MEMORANDUM

SUBJECT: Willard Lot 2 Short Plat SP-13-00006

The following shall be conditions of preliminary approval:

WILLARD LOT 2 SHORT PLAT
 PART OF SECTION 25, T. 18 N., R. 18 E., W.M.
 KITTITAS COUNTY, WASHINGTON

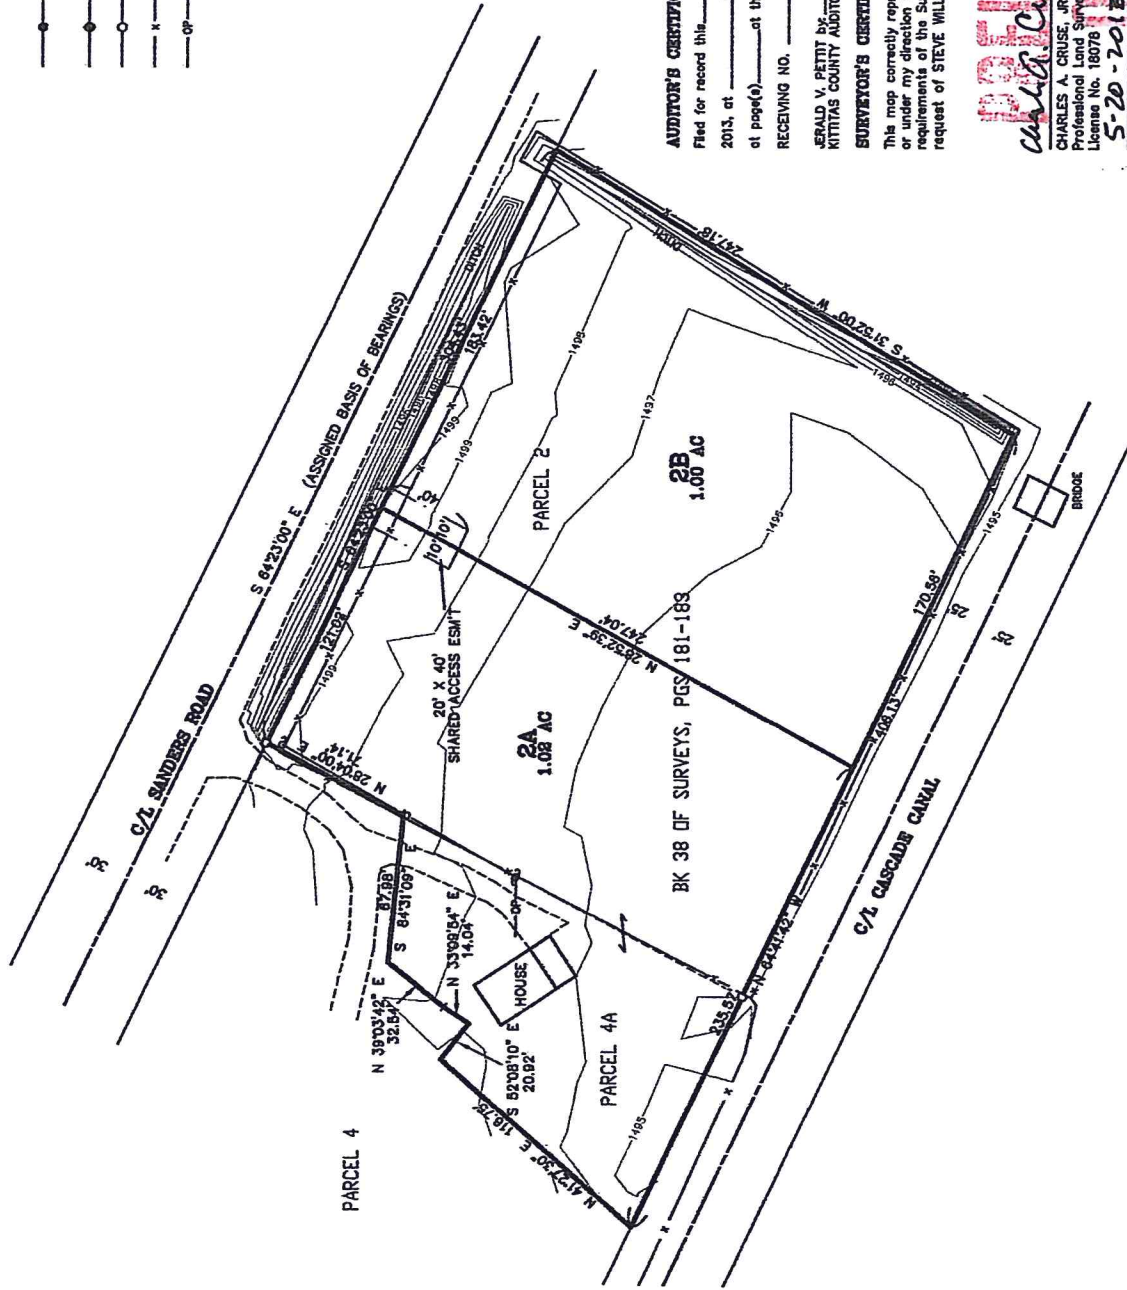
1. **Access:** The applicant has received a road variance to allow both a residential and agricultural access onto the property. See RV-13-10 Willard II.

2. **Joint-Use Driveway:** A joint-use access shall serve no more than two tax parcels. See Kittitas County Road Standards, 9/6/05 edition.
 - a. Access easements shall be a minimum of 20' wide. The roadway width shall have a minimum width of 12'.

- b. The surface requirement is for a minimum gravel surface depth of 6".
 - c. Maintenance of driveway approaches shall be the responsibility of the owner whose property they serve. The County will not maintain accesses.

- d. Any further subdivision or lots to be served by proposed access may result in further access requirements.
3. **Private Road Maintenance Agreement:** The applicant shall meet all applicable conditions of any pre-established or required Private Road Maintenance Agreements.
